From: Contact Centre (CRM) <contact@ribblevalley.gov.uk>
Sent: 20 August 2024 22:44
To: Planning
Subject: Planning Application Comments - 3/2024/0613 FS-Case-640185330

Planning Application Reference No.: 3/2024/0613

Address of Development: Inglemead Waddington Road Clitheroe

Comments: We have the following comments about planning application number 3/2024/0613- proposed demolition of existing single garage and construction of new single storey two bedroom dwelling (Self build) at the end of the rear garden of Inglemead, Waddington Road, Clitheroe BB7 2HN.

project	drawing number		
inglemead	24.25		
name			
proposed site plan			
scale	date	status	revision
1 to 125 @ A1	july 24	planning	A

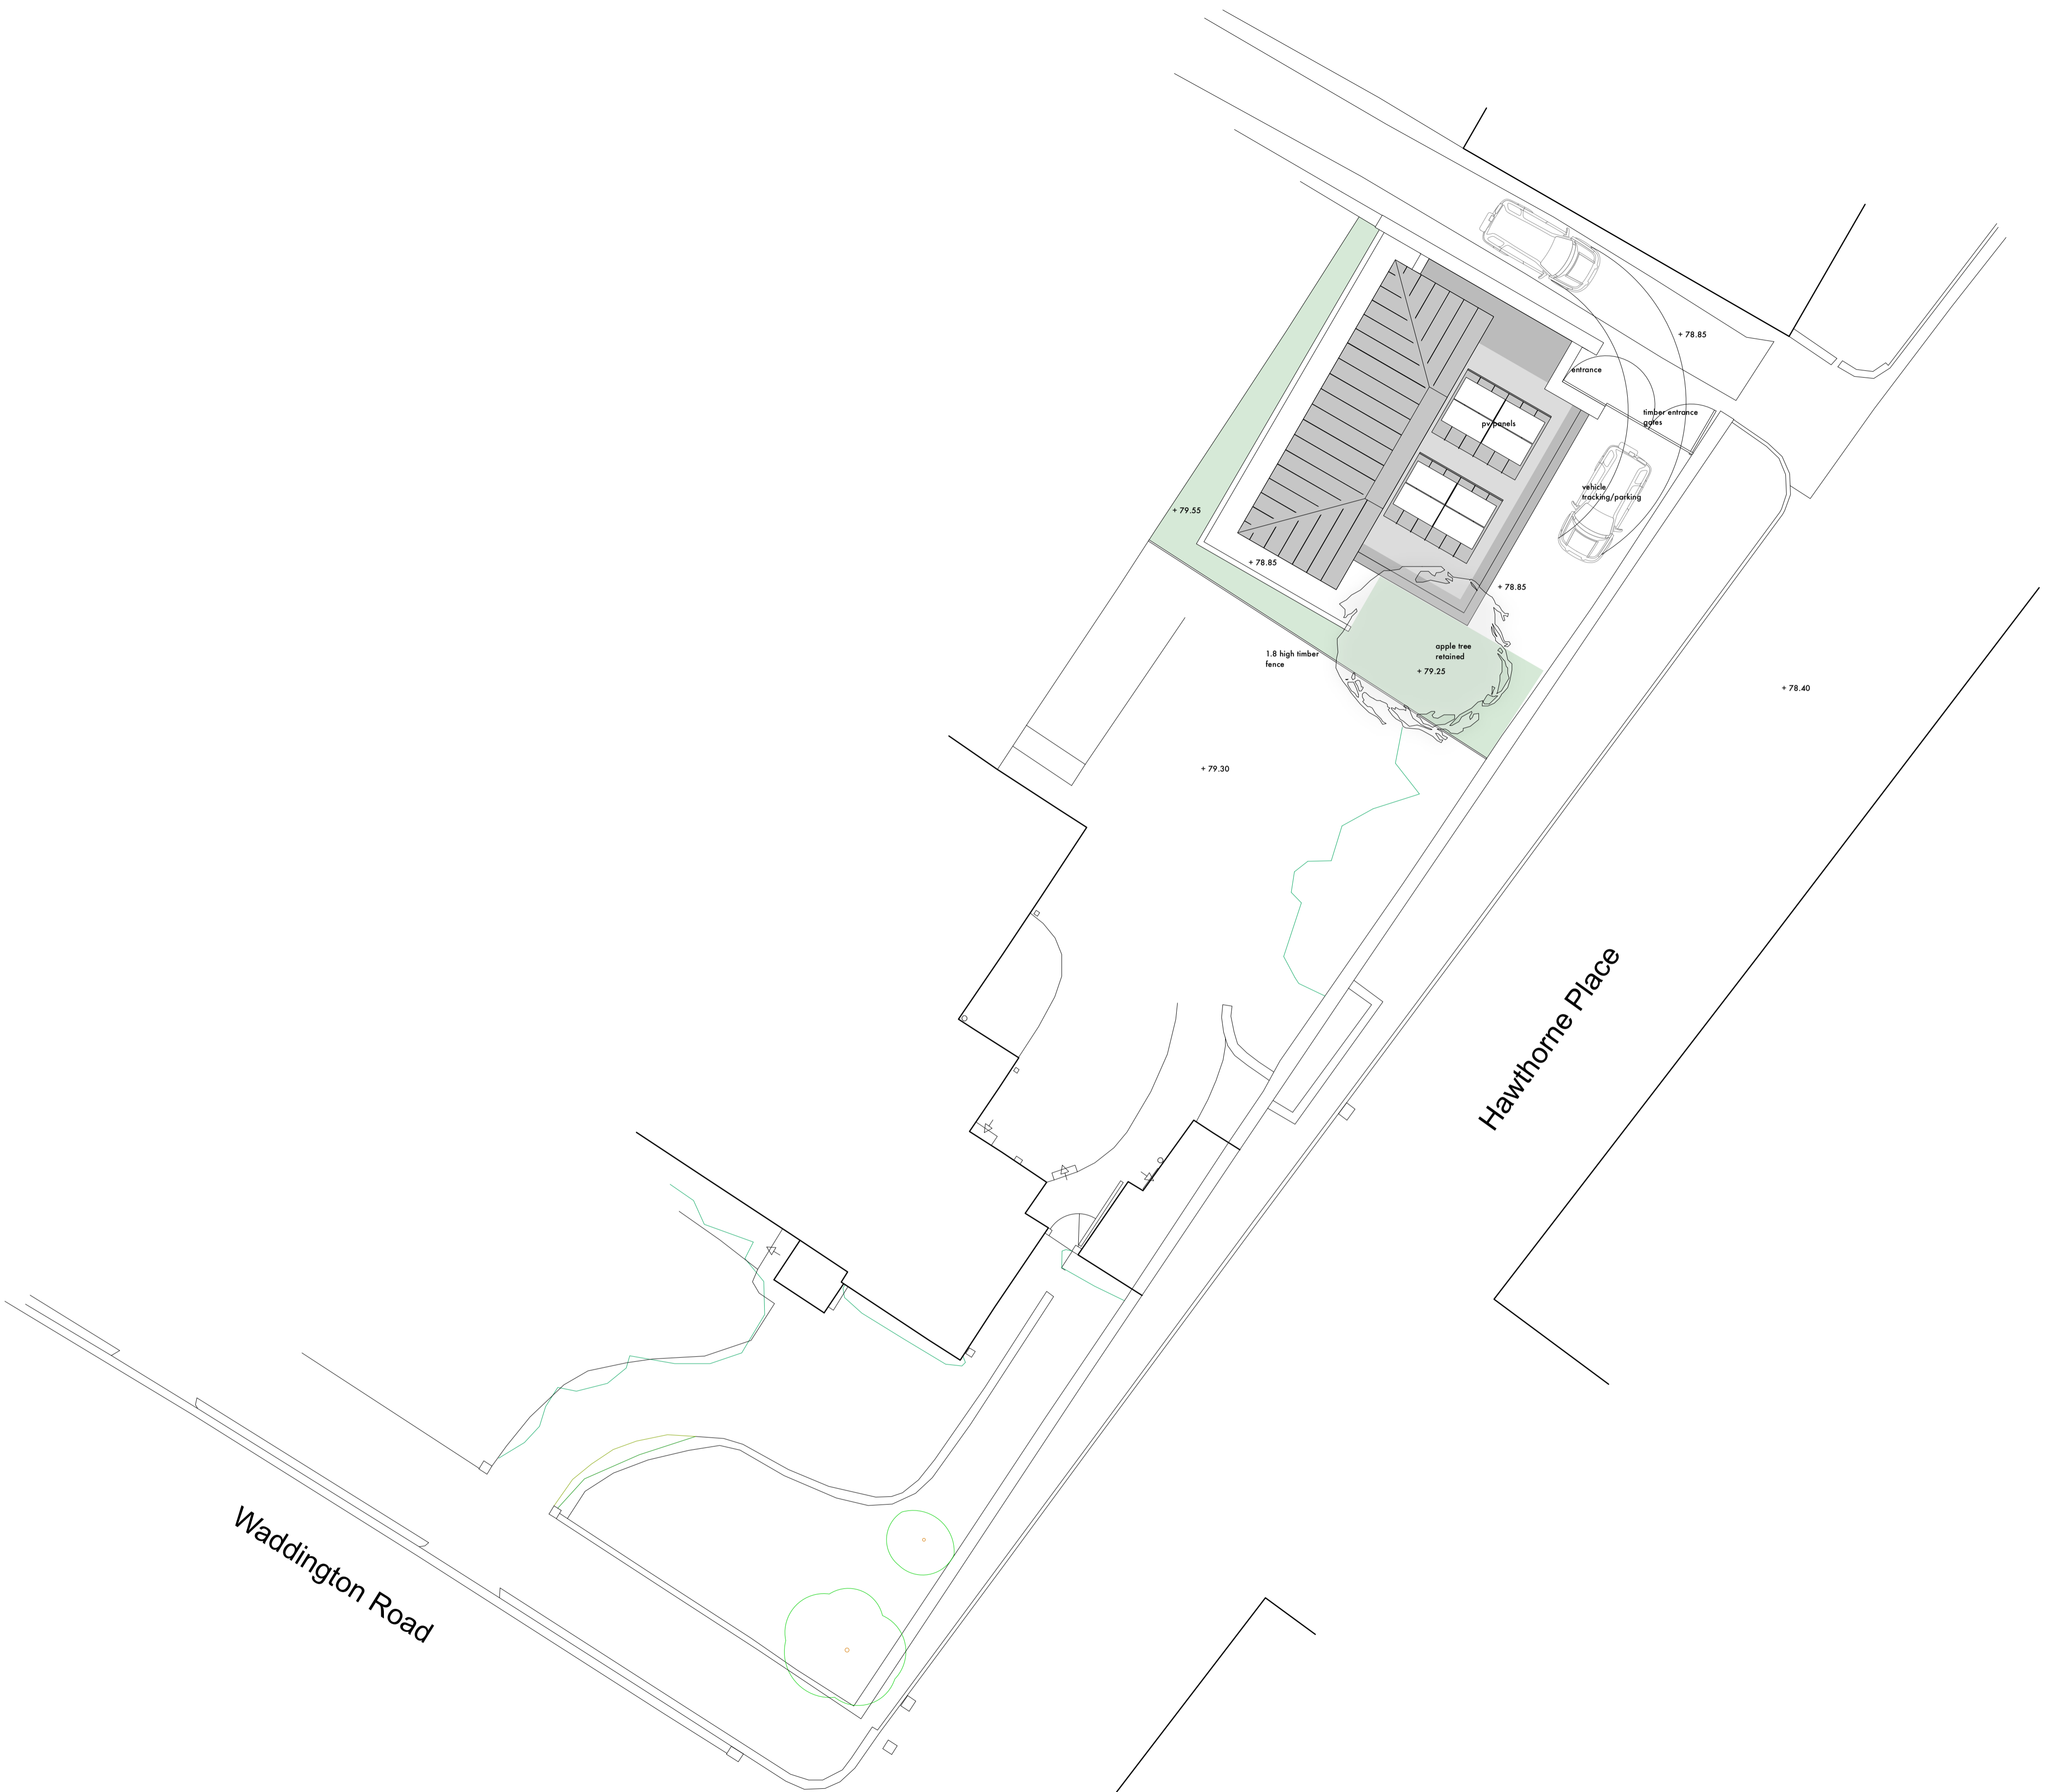
Comments: Having looked at the proposed plans one of the concerns would be parking. The plans are only allowing parking for one vehicle. If the property would be occupied by a two or more vehicle family there would be an issue on a street which is already overstretched by vehicles and parking. Where would visitors park? Another concern would be noise and dirt pollution, especially having to endure this with the new housing development at the end of Hawthorne place. There is also the alleyway that connects Hawthorne place and Eastham street this is where the entrance to the proposed site would be, the alley is full of wildlife and vegetation which complements the area. We hope that a sensible decision can be made regarding this application.

There is parking in the current garage/ site if demolished. Residents on Hawthorne Place will still see a reduction of on street parking spaces available to them in an already congested parking situation where outside working hours, cars are parked on both sides of the narrow street often partially blocking the exit onto Hawthorne Place making the right turn fraught with danger due to poor vision of traffic coming from either direction and schoolchildren walking to school. If there are two cars linked to the property, as is often the case, this would further exacerbate the parking problem. We already often have near misses and [REDACTED], [REDACTED]. The houses opposite the garden wall bordering Hawthorne Place do not have any off-street parking. This is a cul de sac and therefore children do play outside here. Increasing traffic especially a car trying to turn into a drive or reverse out would increase risk to pedestrians. [REDACTED]

[REDACTED]. We feel that anyone trying to access this space regularly will become fed up and inevitably will resort to street parking thereby increasing congestion.
